EPC STORMWATER REVIEW COMMENTS
 IN ORANGE BOXES WITH BLACK TEXT

EL PASO COUNTY GRADING AND EROSION CONTROL PLAN CHECKLIST

EPC Project Number: **PPR255**

SM	STORMWATER ENTERPRISE	SEEDING & MULCHING		
		ISSUED: 10/7/19	REVISED: 8/19/2020	DRAWING NO: 900-SM

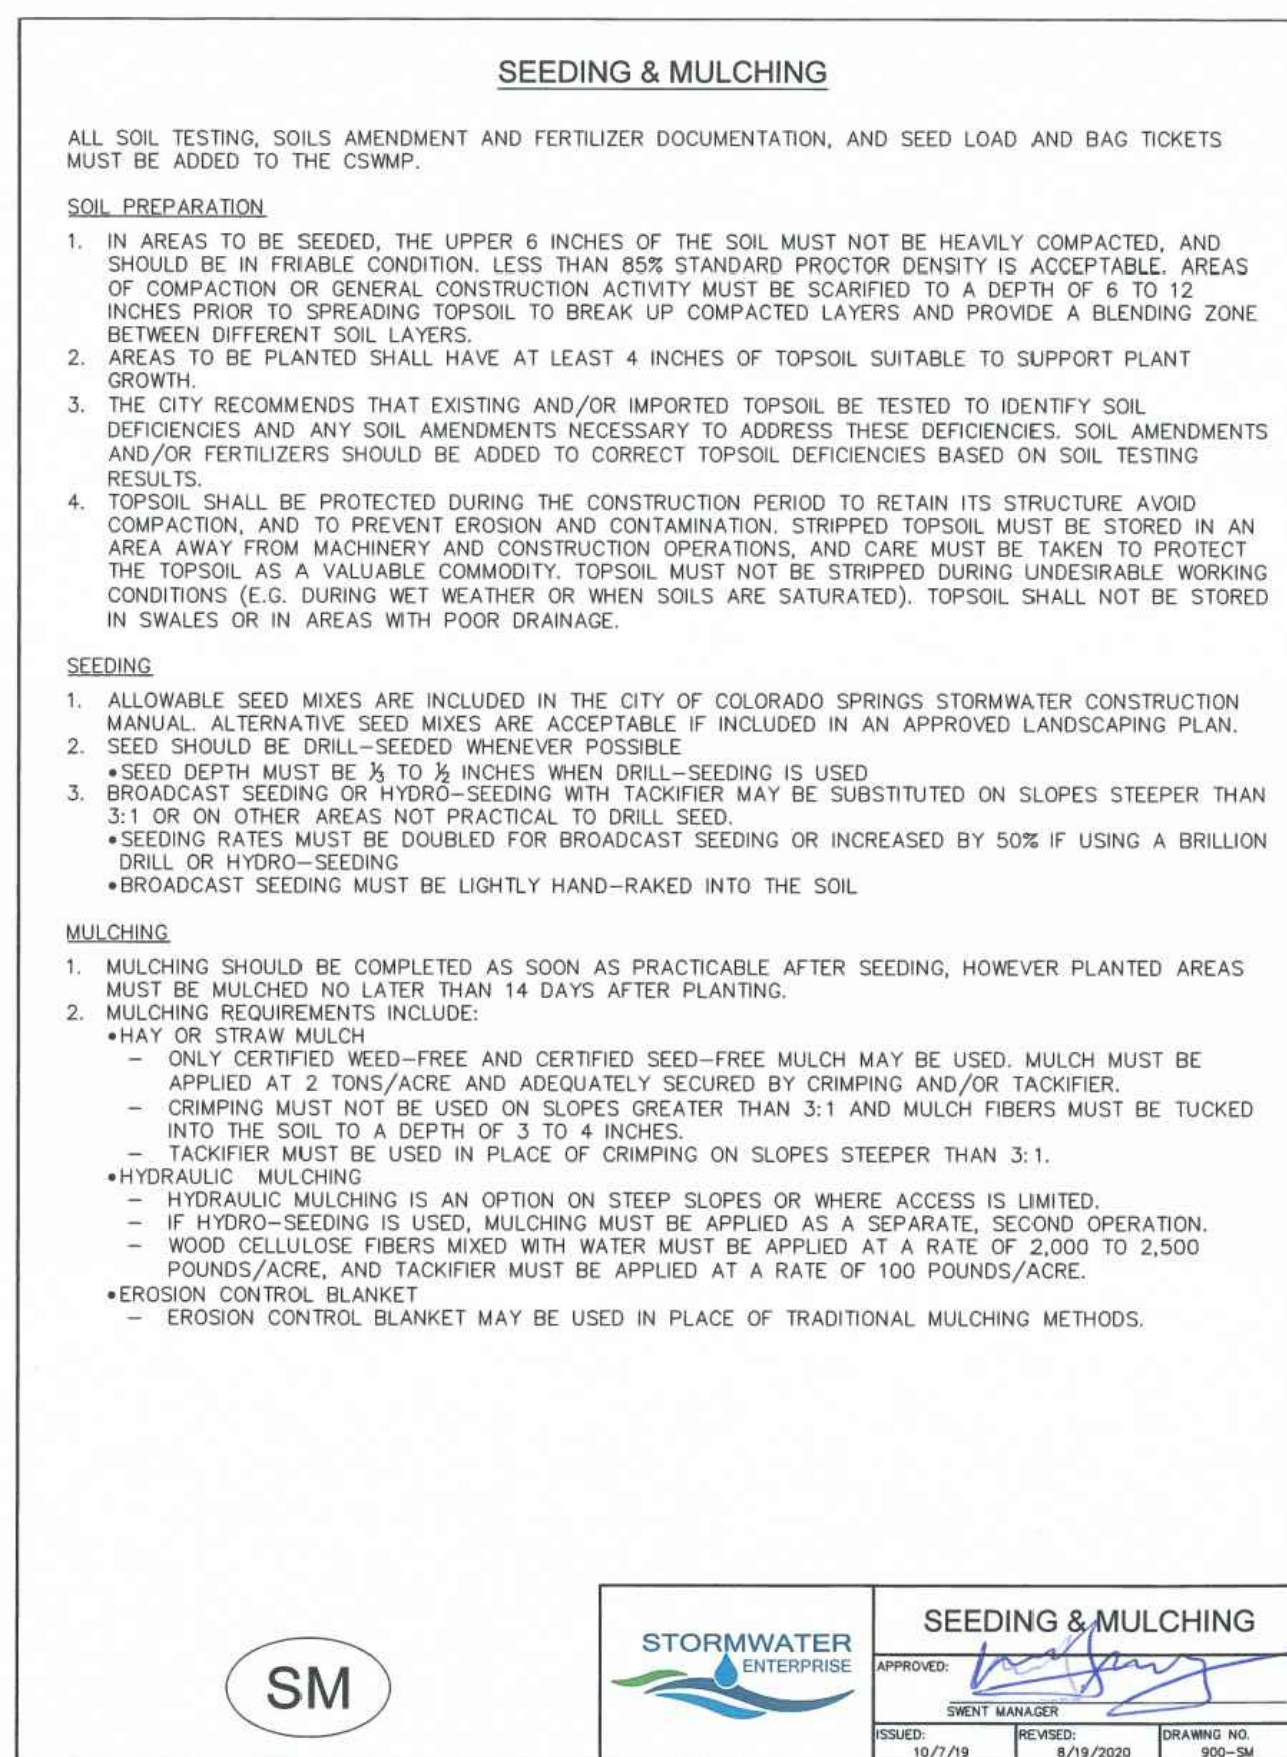
Applicant	EPC
y	Dewatering operations to include locations of diversion, pump and discharge(s) as anticipated at time of design		N/A
z	All proposed temporary construction control measure details. Custom or other jurisdiction's details used must meet or exceed EPC standards		N
aa	Any off-site stormwater control measure proposed for use by the project and not under the direct control or ownership of the Owner or Operator		N
bb	Existing and proposed permanent storm water management facilities, including areas proposed for stormwater infiltration or subsurface detention		N
cc	Existing and proposed easements (permanent and construction) including required off-site easements		Y
dd	Retaining walls shall not to be located in County ROW unless approved via license agreement. A building permit from Regional Building Department is required for walls greater than or equal to 4 feet in height, series of walls, or walls supporting a surcharge and must be design by P.E.
